Item No. **Report of the Head of Development Management and Building Control**

Address: 28 DAWLEY AVENUE HILLINGDON

Development: Erection of a single storey rear extension, a double storey side and single storey front extension/ front porch

LBH Ref Nos: 14440/APP/2024/428

Drawing Title
Proposed Elevations

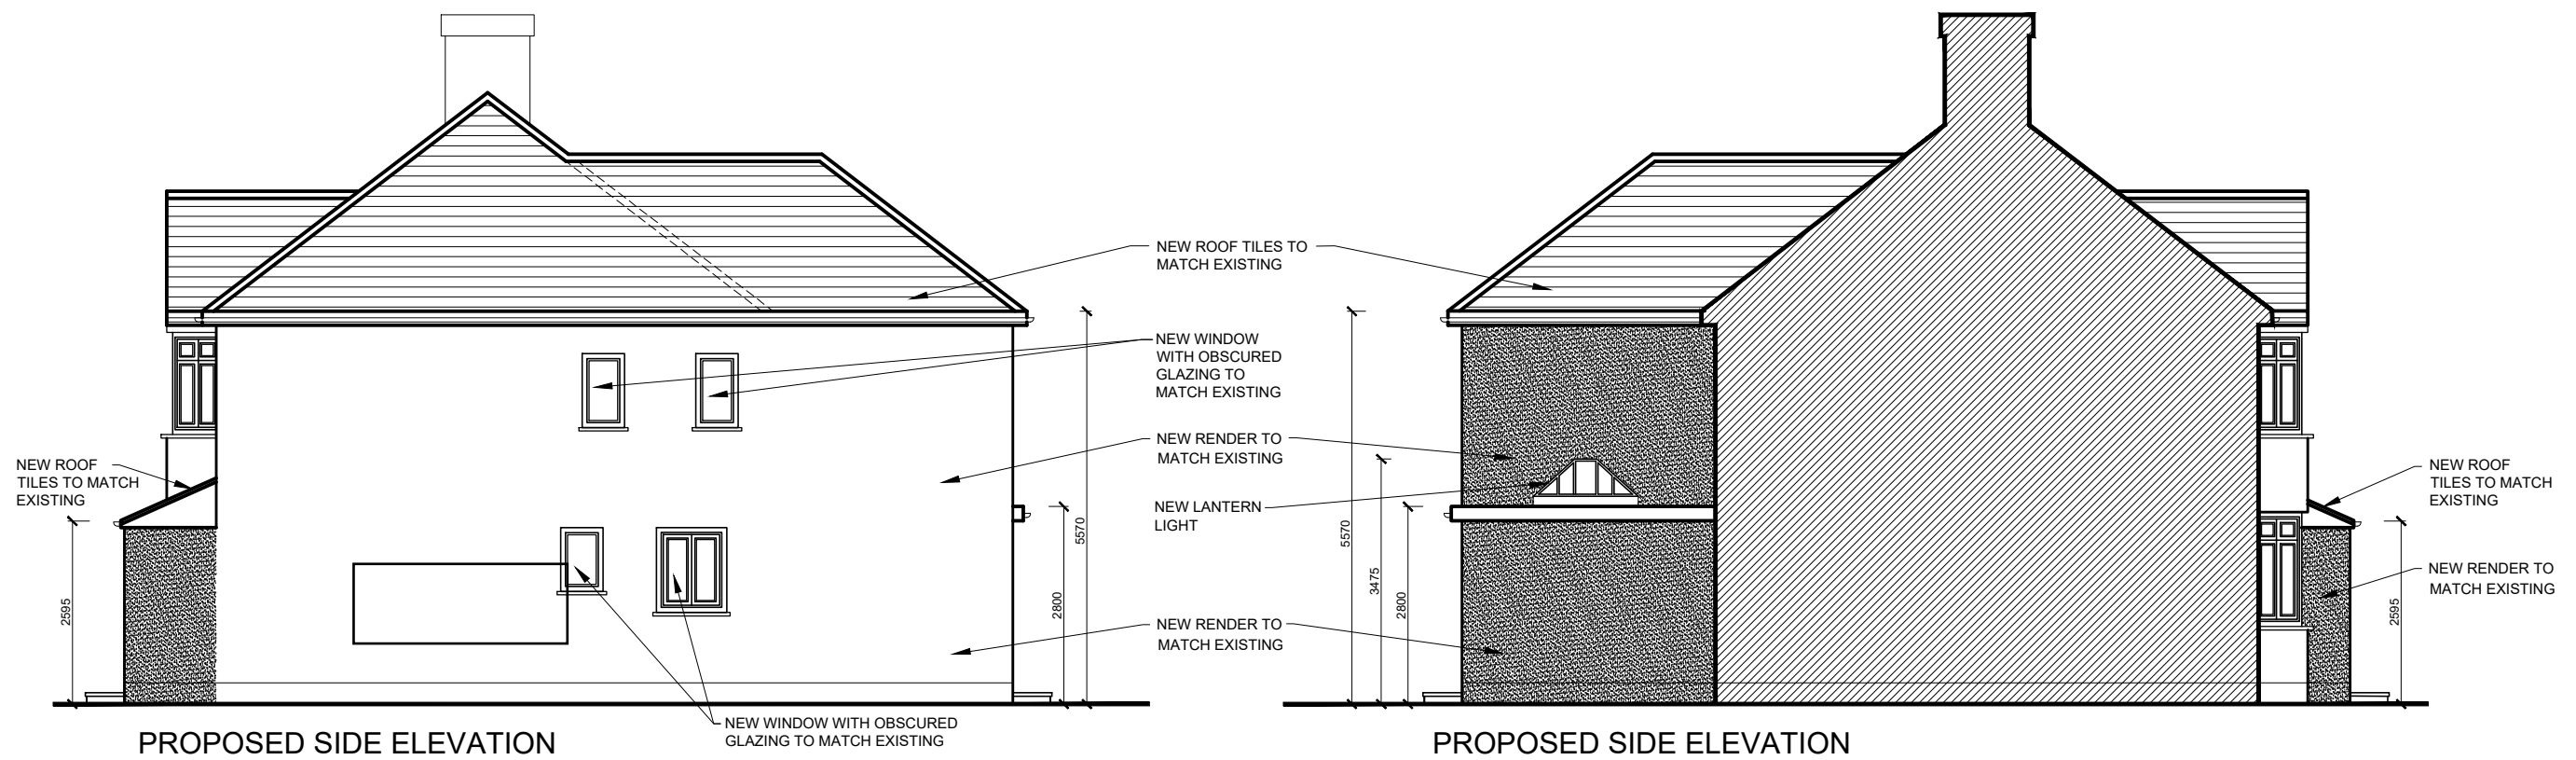
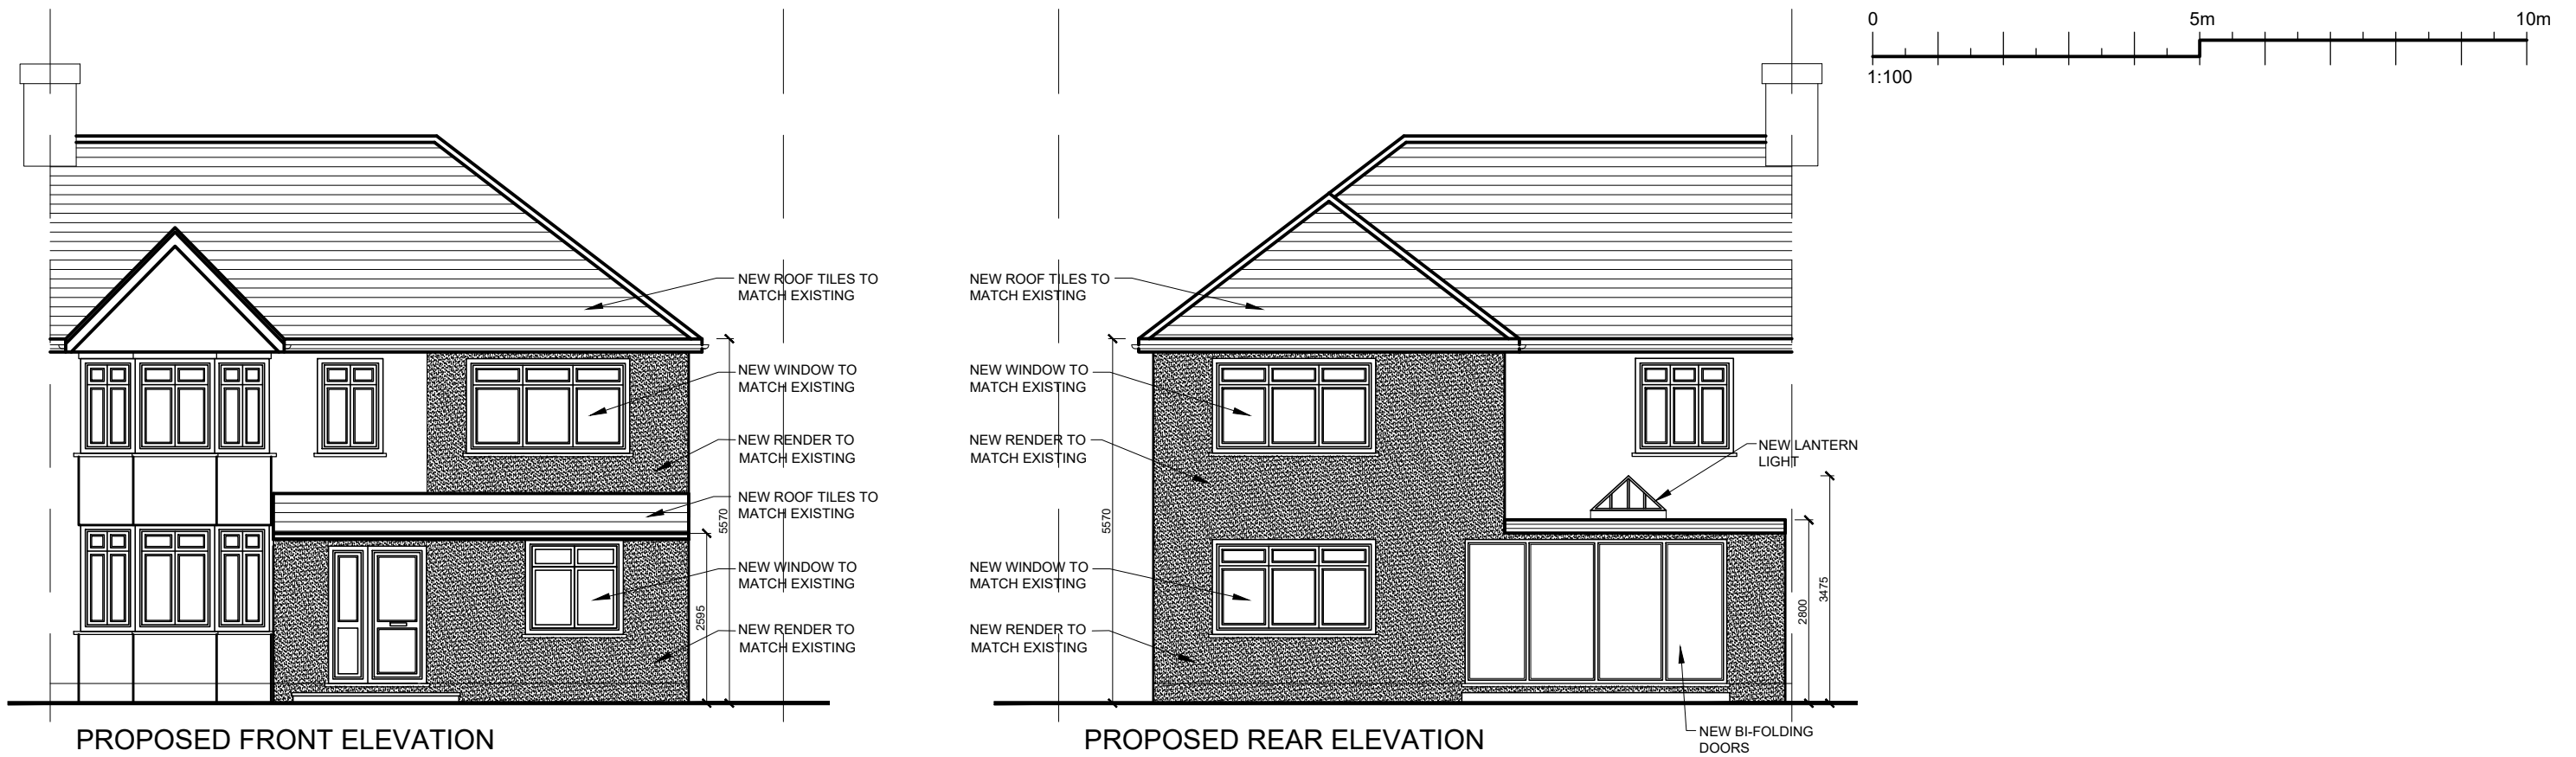
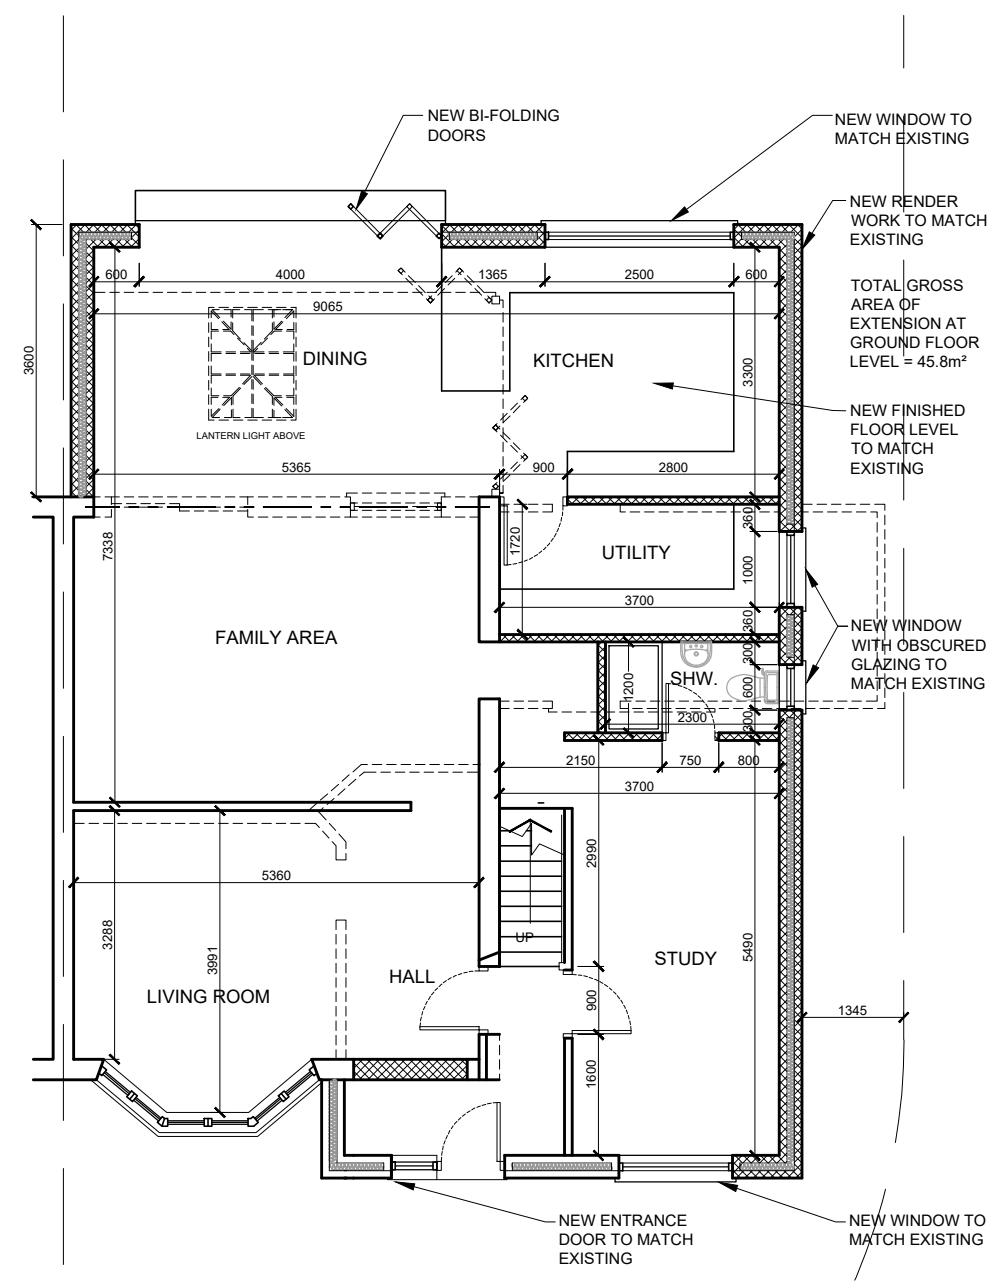
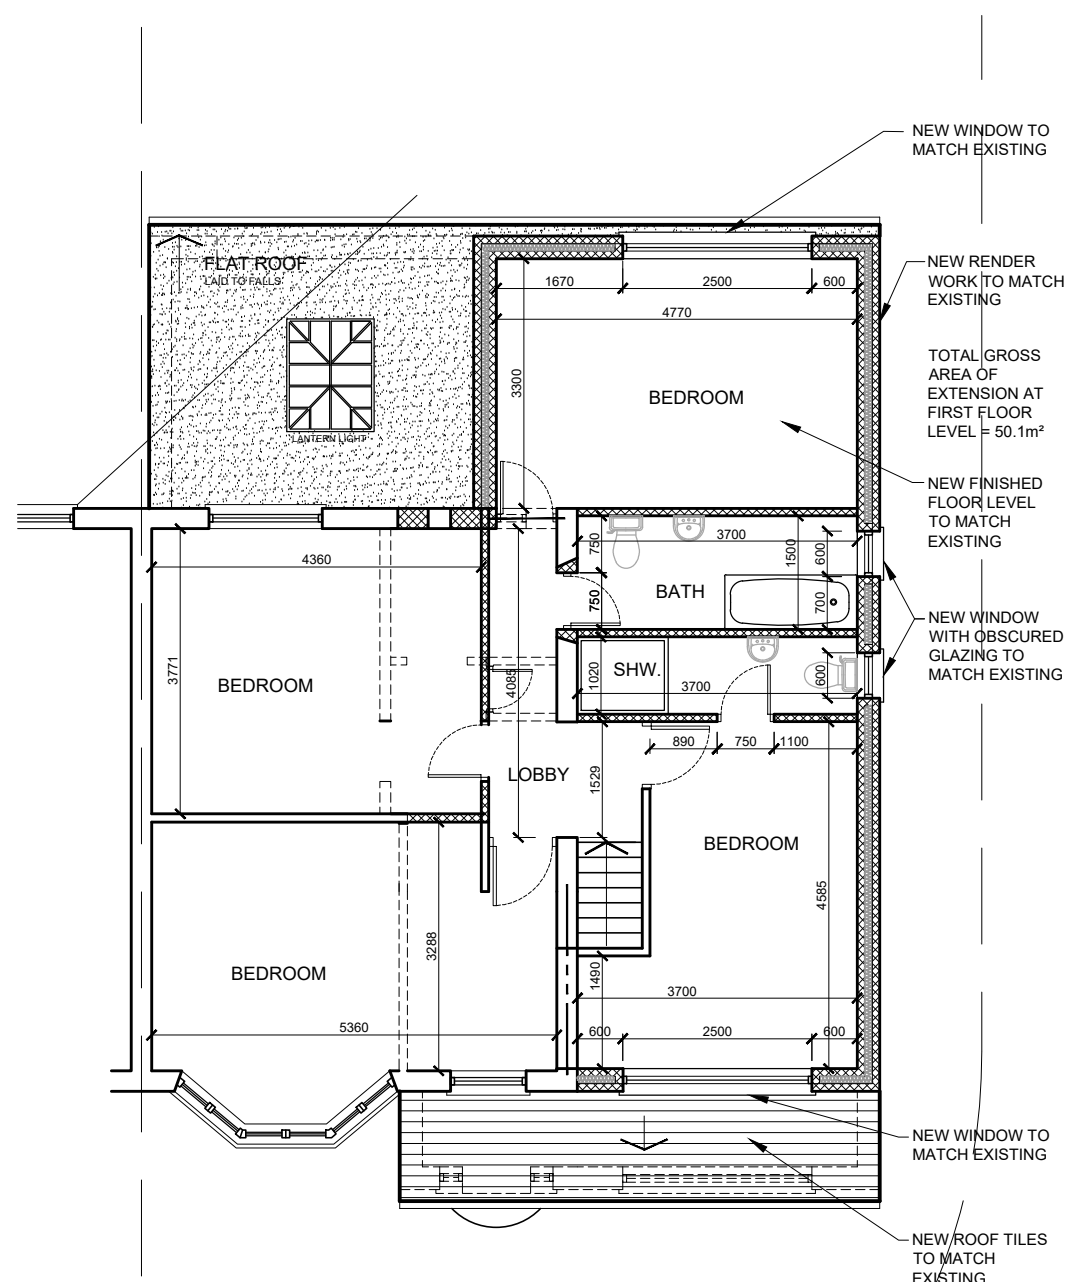
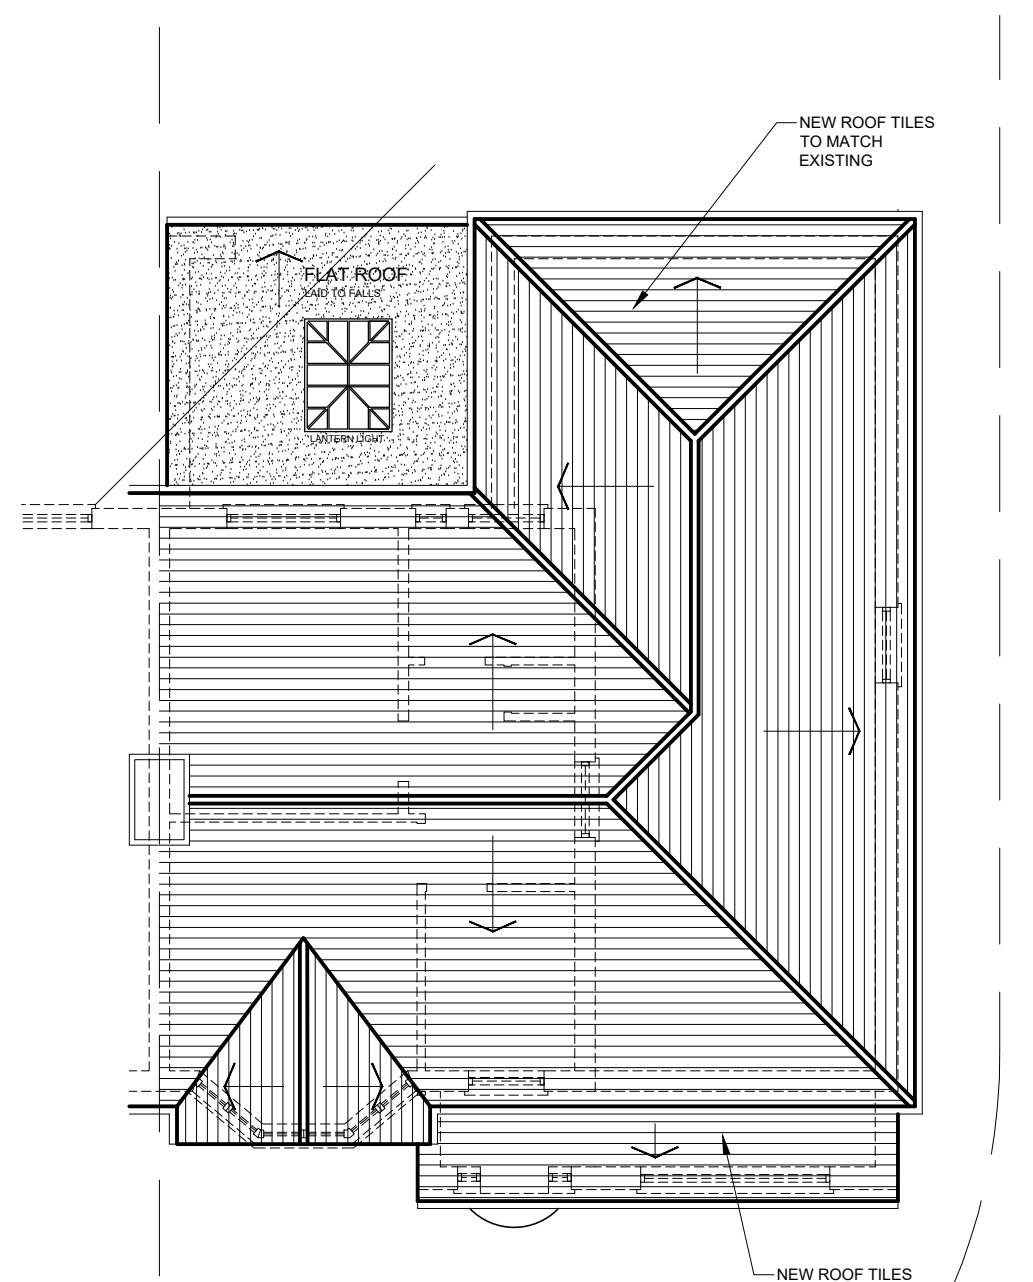
The proposed side extension fails to comply with the requirements of policy DMHD1. At a width of 4m the side extension would exceed half the width of the original dwelling. Furthermore, the side extension is not set back 1m from the front elevation at both levels and actually extends forward of the existing front building line. The property occupies a prominent corner plot and the extension would leave a gap of just 0.694m to the side boundary at its narrowest point for its full height and would project further beyond the return building line established by the adjacent properties in Chester Close. The proposed extension would therefore detract from the open spacious character of this junction. The set back of the properties in Chester Close and the space to the side at the application dwelling, albeit including a single storey element, gives an element of spaciousness on the street scene alongside this section of the highway. The proposed extension would fill in a significantly large portion of the space to the side of the existing dwelling, and would bring the built form into an uncharacteristically close relationship to the road such that it would become visually intrusive in the street scene.

It is considered that the proposal fails to address the concerns which formed reason for refusal 1 from the previous application. The proposed extension by reason of its size, scale, bulk, height, depth, width, proximity to the side boundary and projection forward of the return building line along Chester Close, in this open prominent position, would result in the closing of an important gap characteristic to the area, resulting in a cramped appearance. The proposal would therefore represent an overdevelopment of the site to the detriment of the visual amenities of the street scene and the character and appearance of the surrounding area. The proposed development is therefore contrary to Policy BE1 of the Hillingdon Local Plan: Part One - Strategic Policies (November 2012), Policies D4 and D8 of the London Plan 2021 and Policies DMHB11; DMHB12 and DMHD1 of the Hillingdon Local Plan - Part Two.

The proposed extension would be largely screened from Number 30 by the host dwelling. The rear extension at a projection of 3.3m is not considered to give rise to an unacceptable loss of light or outlook. The application includes a plan indicating the 45 degree line of site
